## SOILS AND GEOLOGY STUDY

**Canyon Creek Ranch  
El Paso County, Colorado**

**JOB NO. 189360**

**June 24, 2022**

## FINAL PLAT

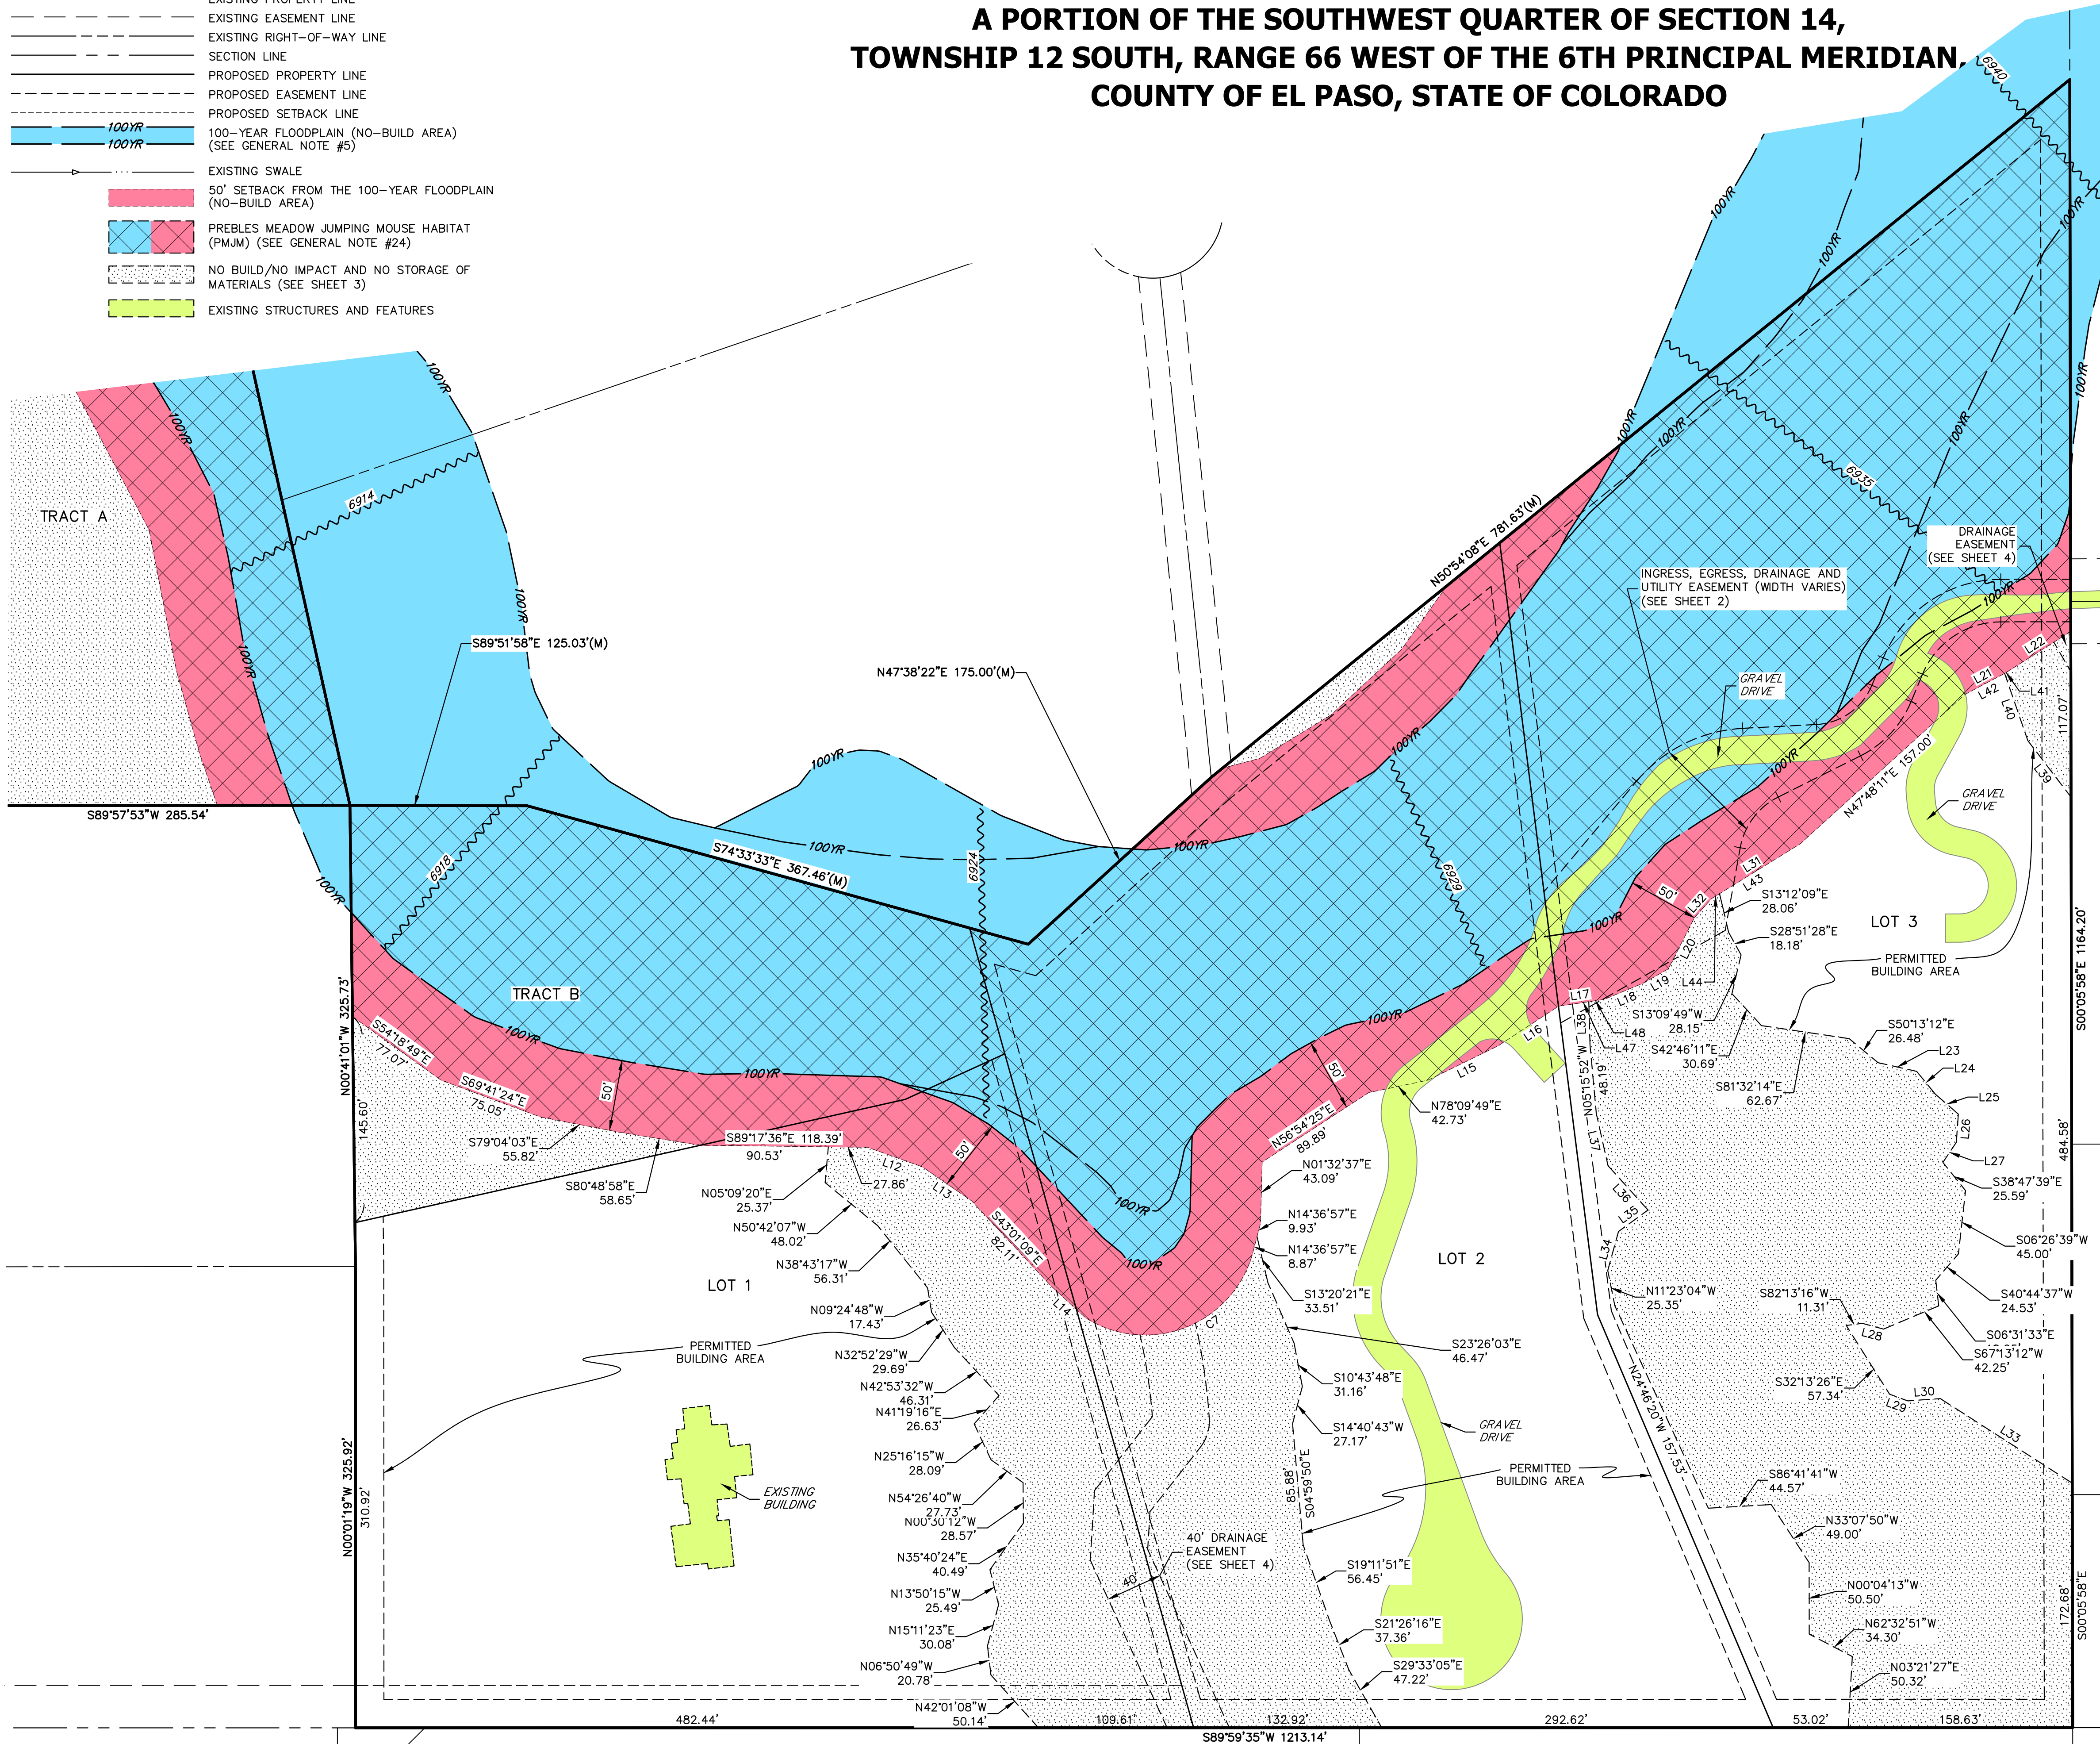
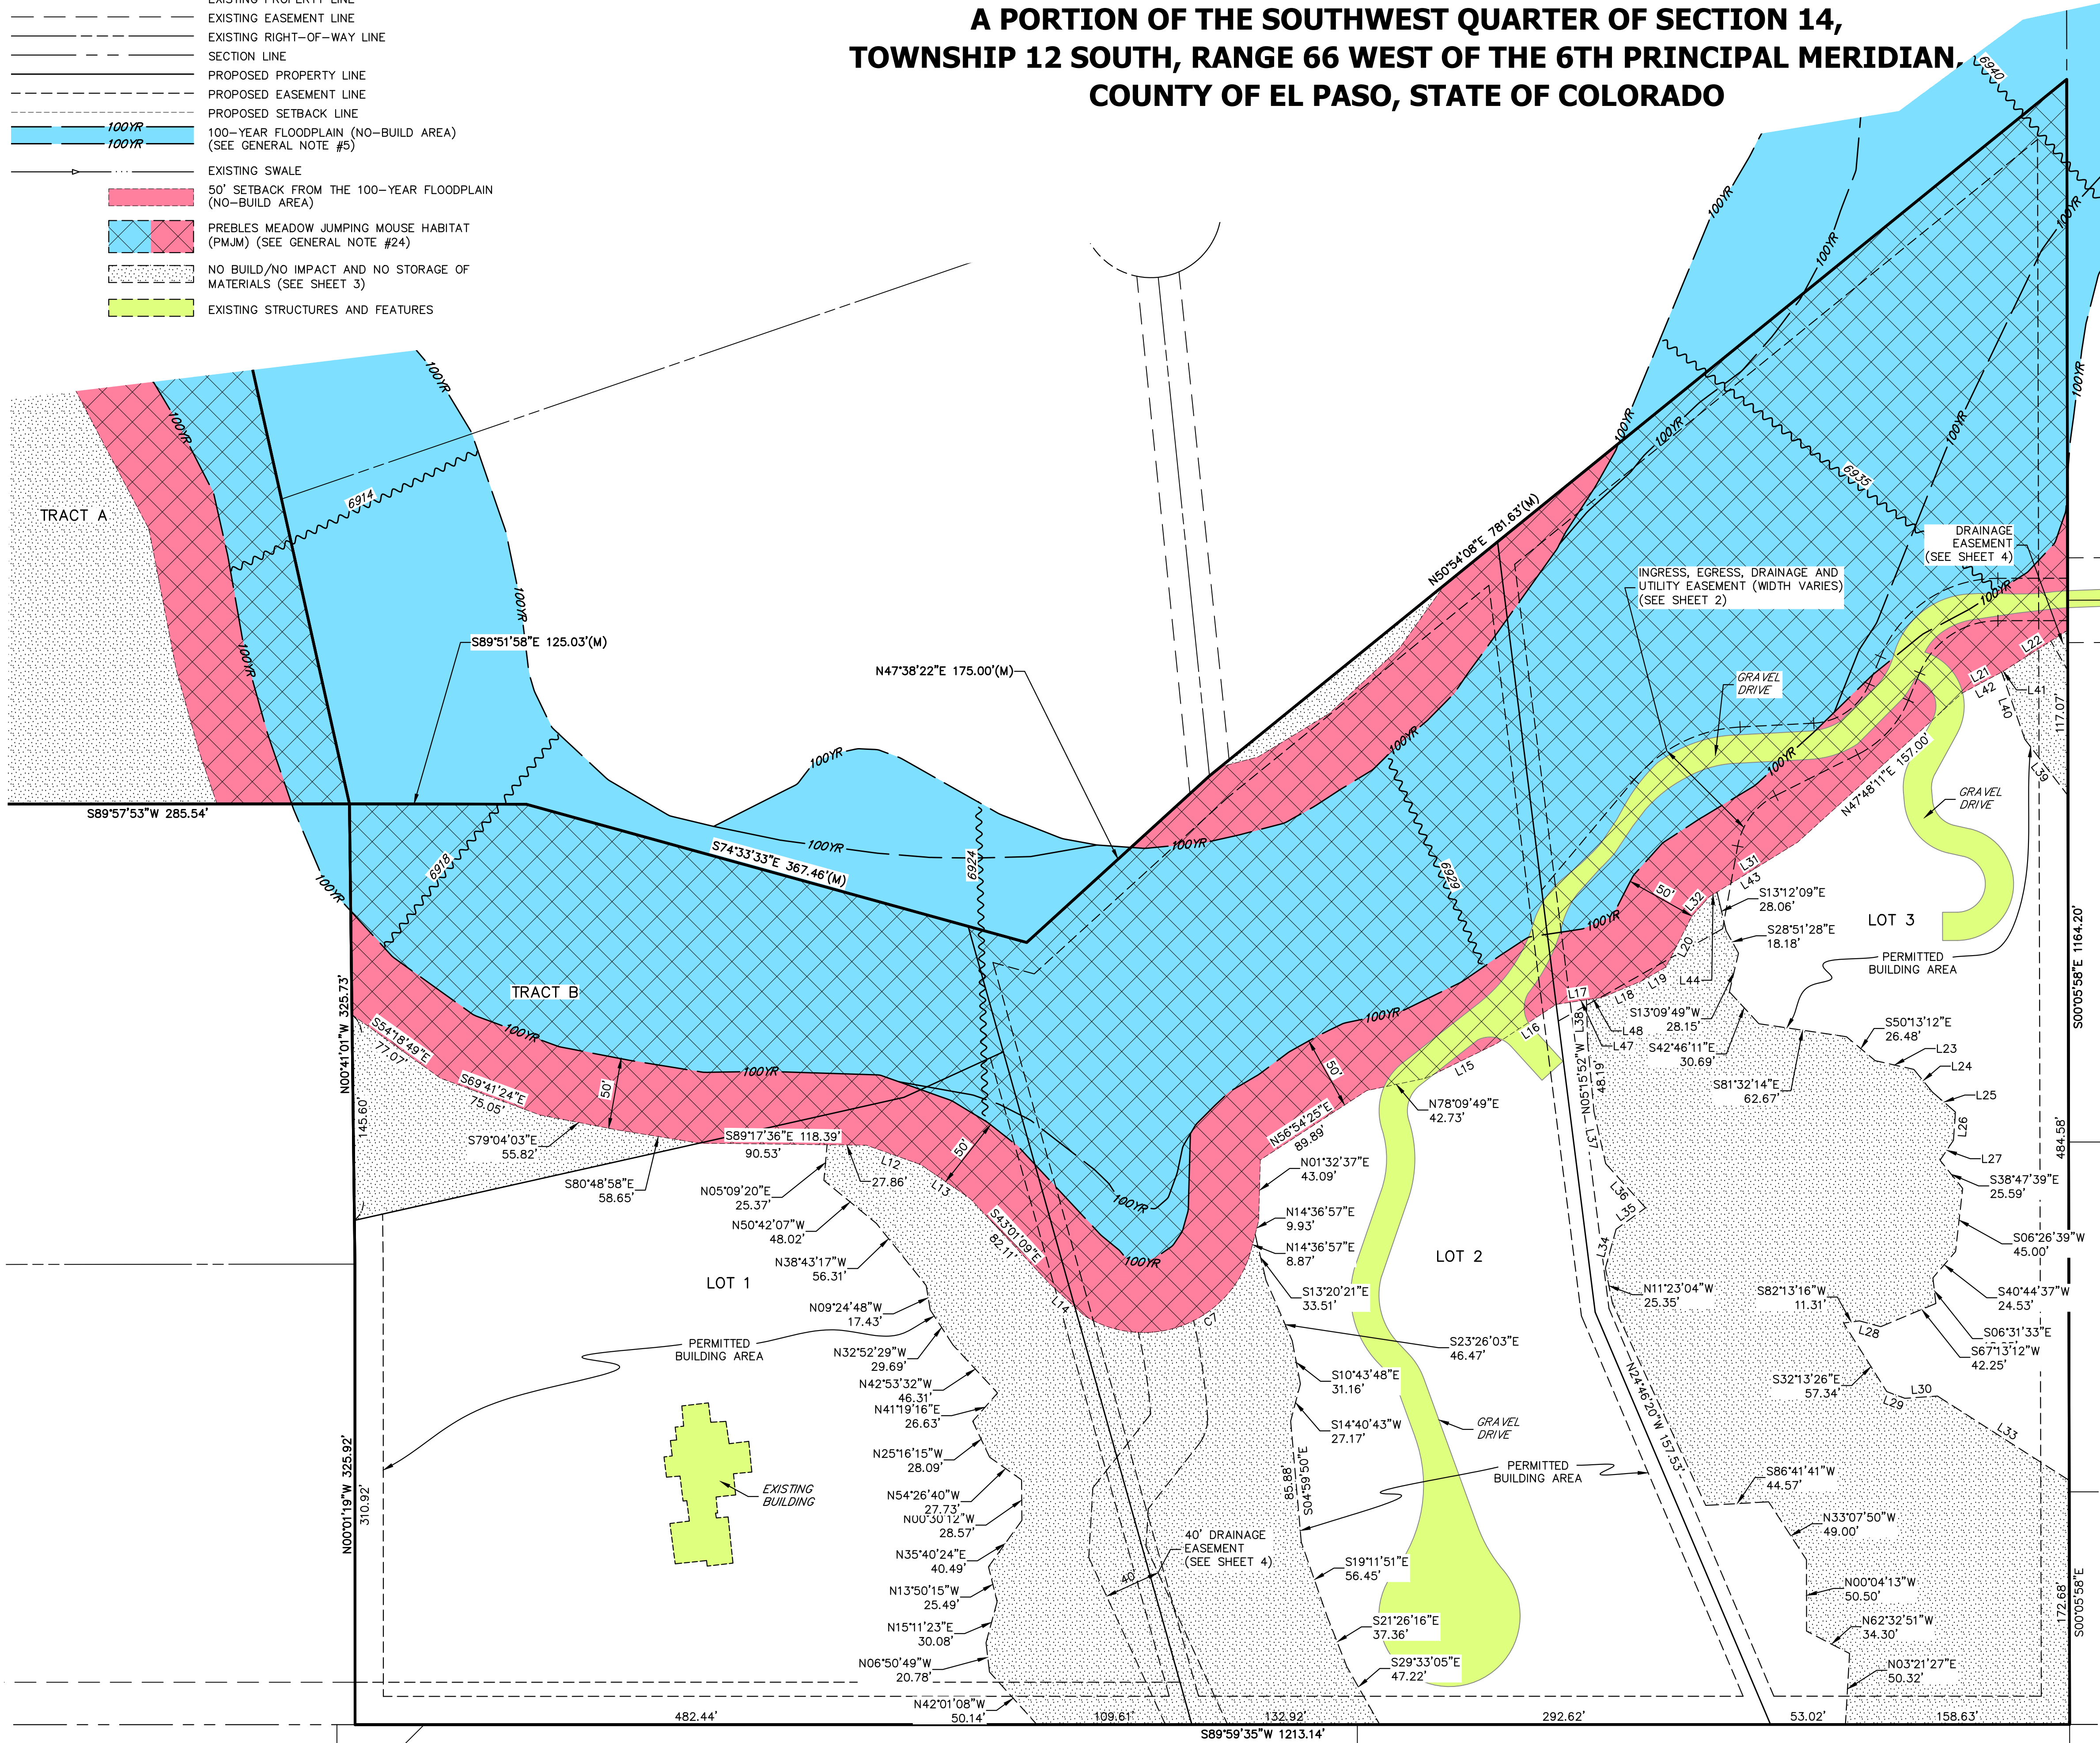
There is significant slope on the property. Please identify all areas of steep slopes (greater than 30%) and depict them on the map. they are required to be depicted as no-build areas.

Identify the minimum distance the houses should be located from the top of the ravine.
